Located At 31 SUMAC ST

Job ID: 2012-04-3820-SF

has permission build a 26 by 32 foot Single Family Residence.

**RE:** Review Comments for Single Family Site Plan

Drawing file: 2012-04-3820-SF / Sumac St Floor Plan, Cross Section.pdf

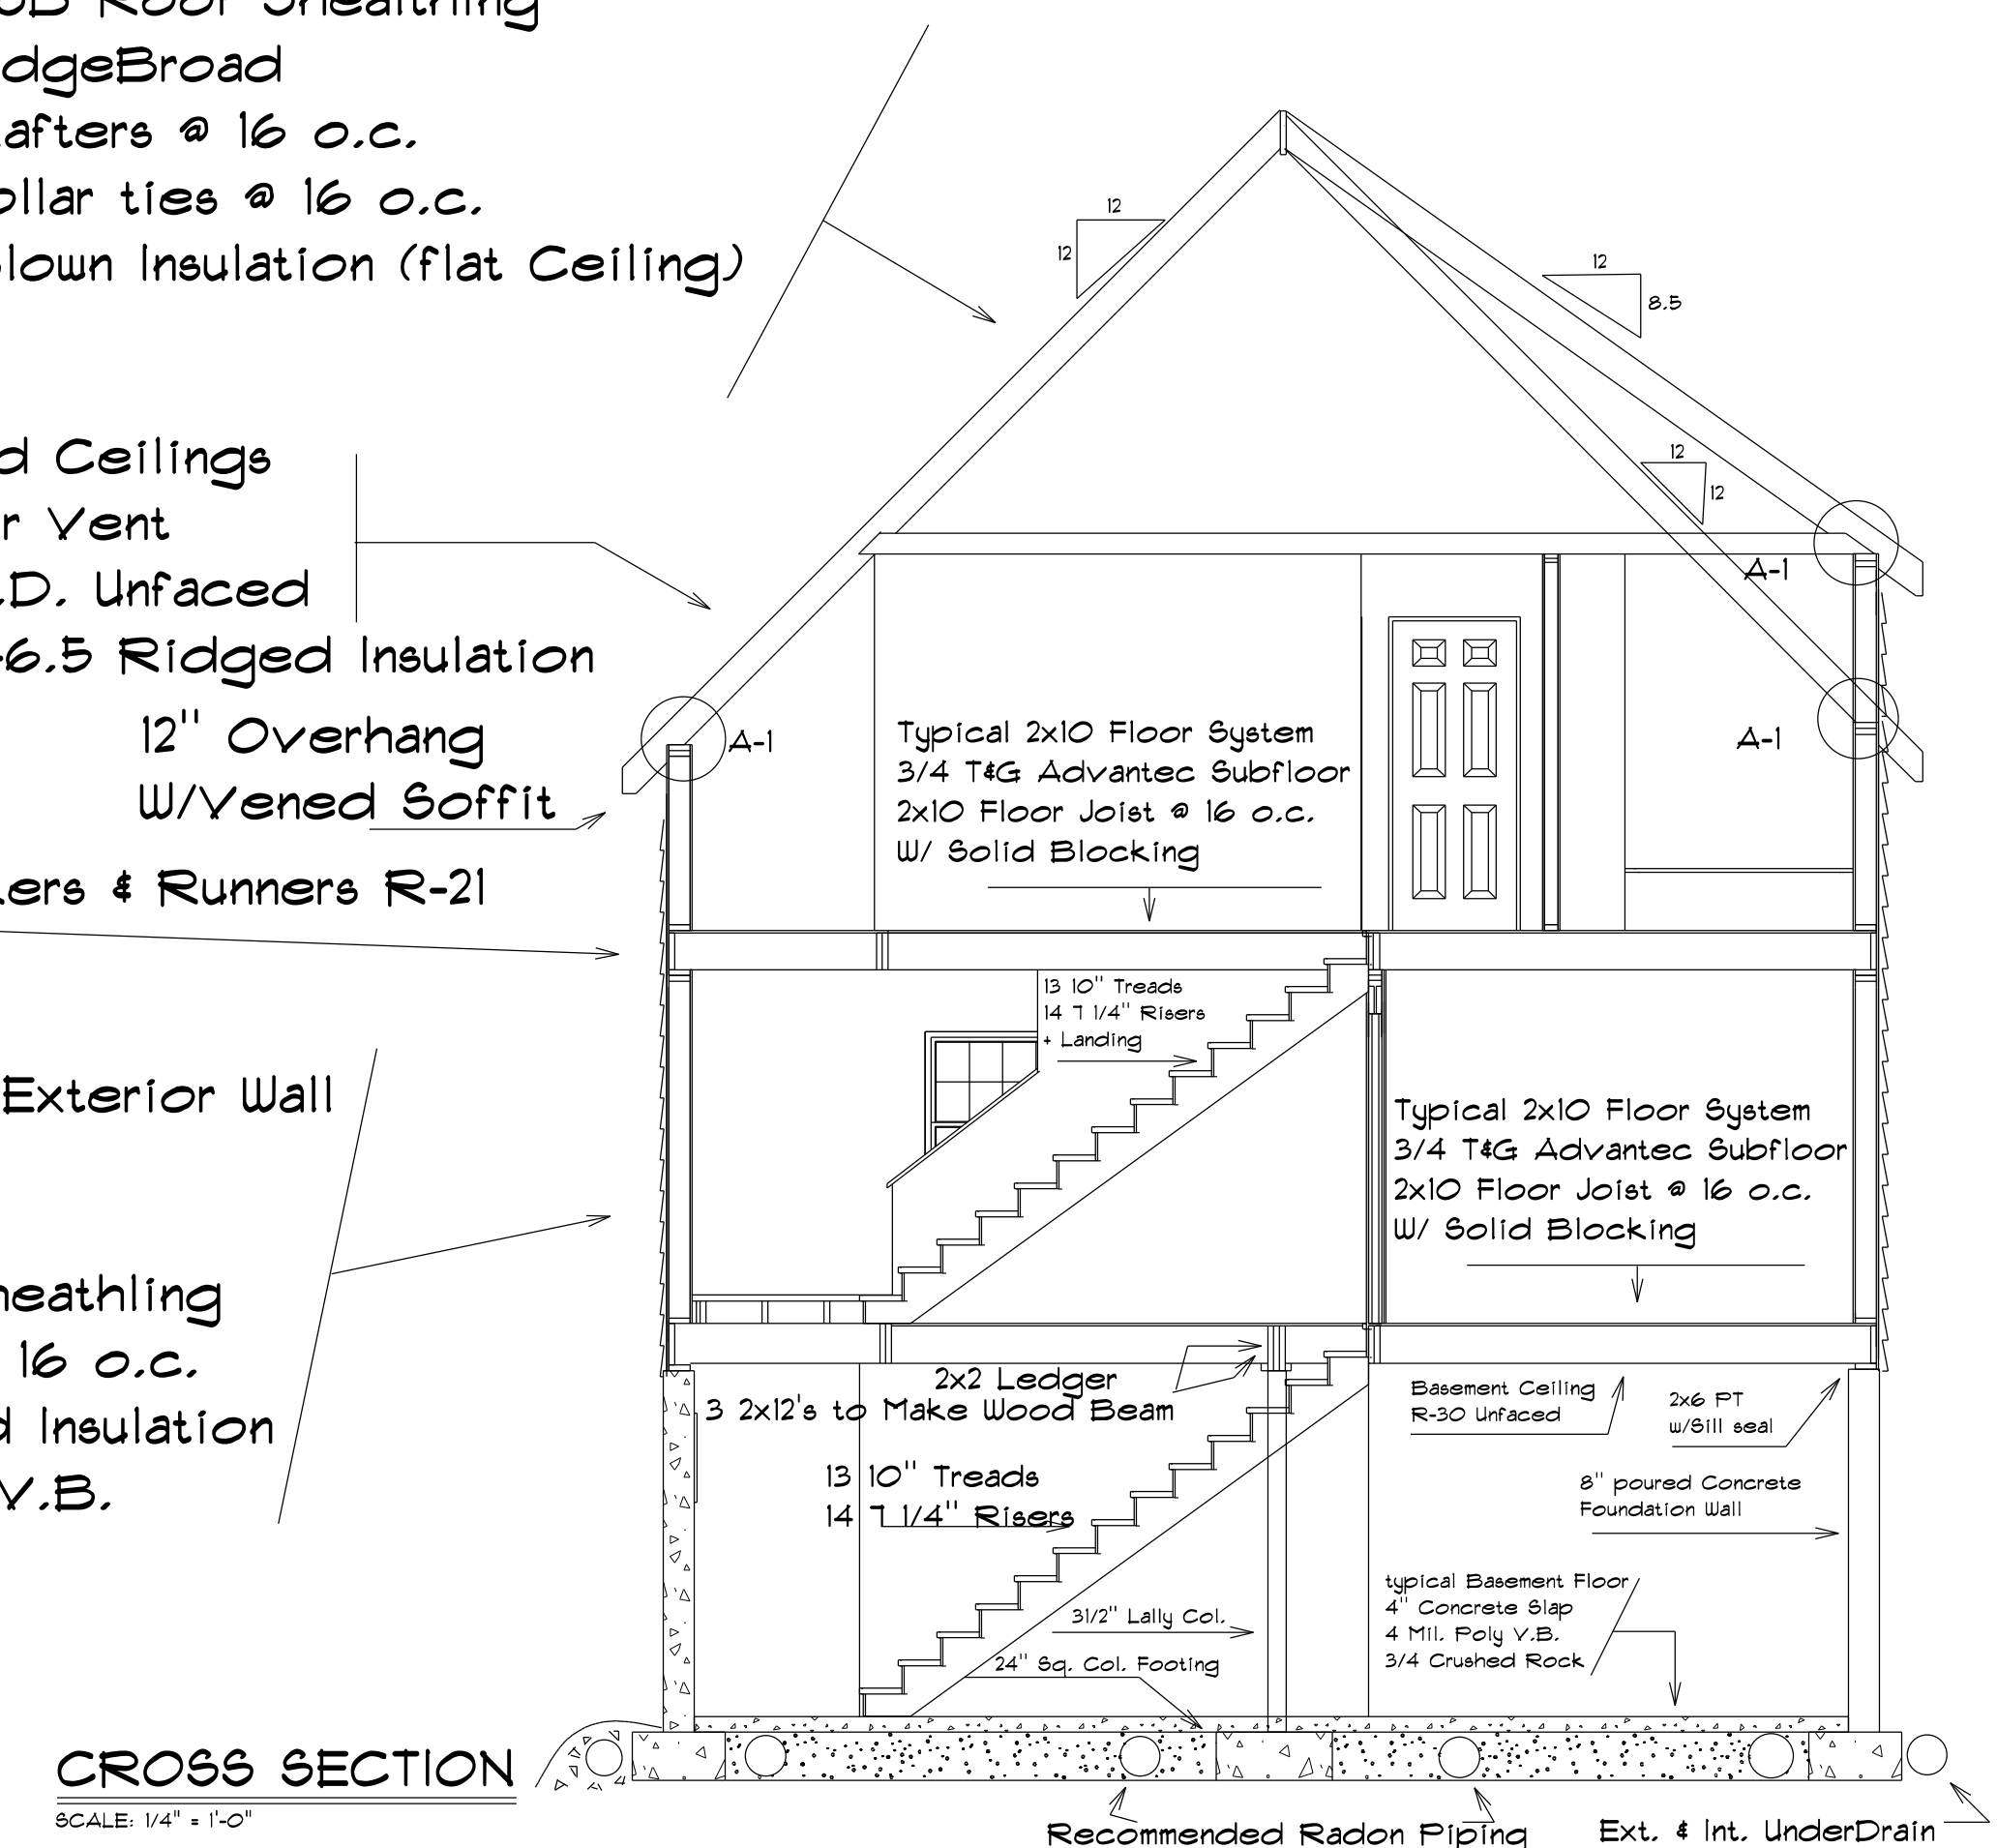
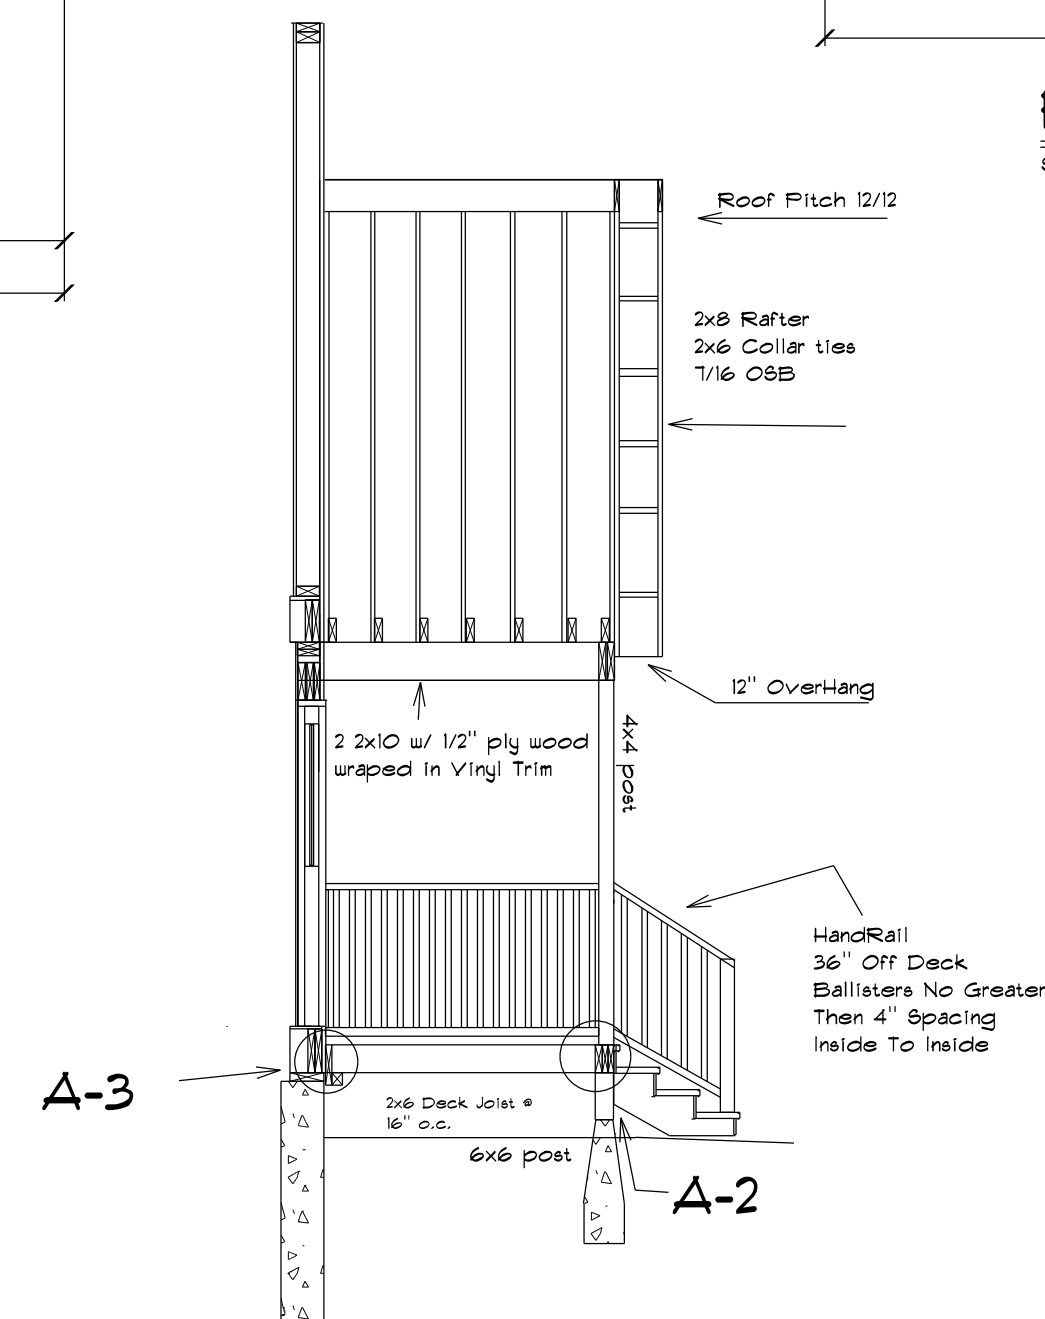
11. Owner is amending plans for a Structural Ridge in compliance with Section R802.3 & R802.3.1 of MUBEC.
12. R502.6 Bearing. The ends of each joist, beam or girder shall have not less than 1.5 inches of bearing on wood or metal and not less than 3 inches on masonry or concrete except where supported on a 1-inch-by-4-inch ribbon strip and nailed to the adjacent stud or by the use of approved joist hangers.

Please submit specification (From your Supplier) for the Structural Ridge amendment, and how it will be posted to the foundation.

*Note: Enclosed accessible space under stairs shall have walls, under-stair surface and any soffits protected on the enclosed side with 1/2-inch gypsum board. Attached is our minimal requirements for interior Girder spans- the plan specification do not appear to meet our minimal building code requirements. JGR.*
